Your Ref: OWQC15418
Our Ref: EP/106/17/PL
Please ask for:
Mr A Wood

1st September 2017

Loft conversion of existing building.
The Dolphins (east) South Strand EAST PRESTON

PROPOSED SOUTH / REAR SIDE ELEVATION

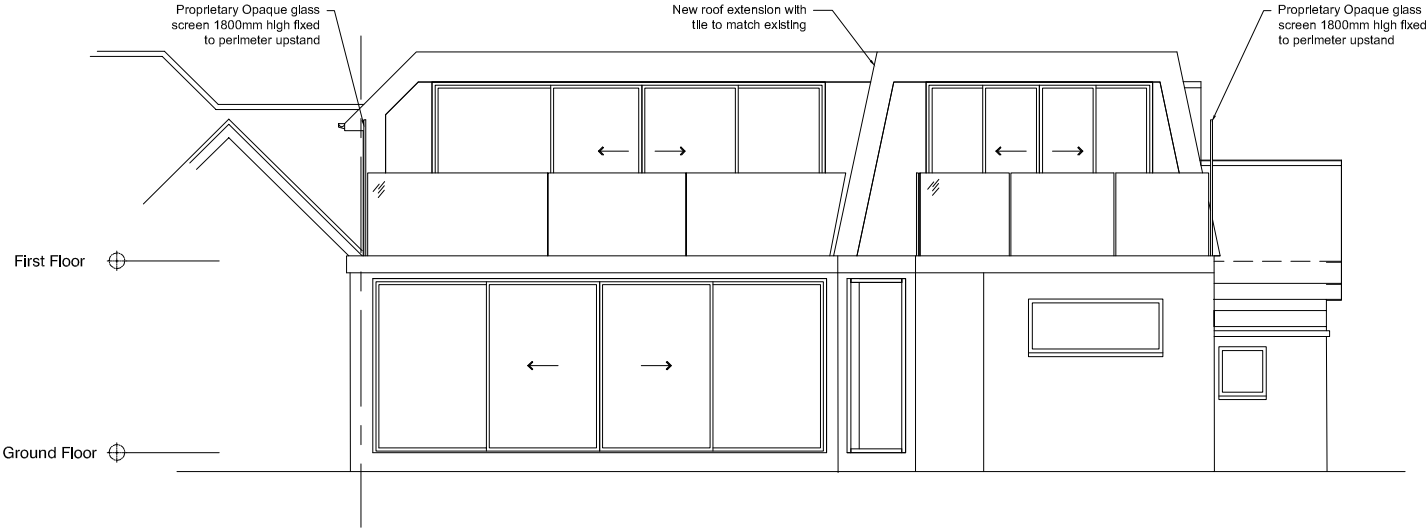
The council agreed to object to this Application as it is contrary to the made East Preston Neighbourhood Plan (Policy 2: Design in Character Area One) as it does not protect the view from the beach. The proposed south elevation will be a major modernisation on the existing property.

Furthermore, the council objects to this Application as it believes the proposal is unsympathetic to this c1911 property, will compromise the look of this building and will result in an unbalanced property very much of two halves. This is contrary to Policy 1: Housing General Principles as the proposed alterations are not deemed to reflect or enhance the architectural and historic character and scale of the surrounding buildings in this case Dolphins (West).
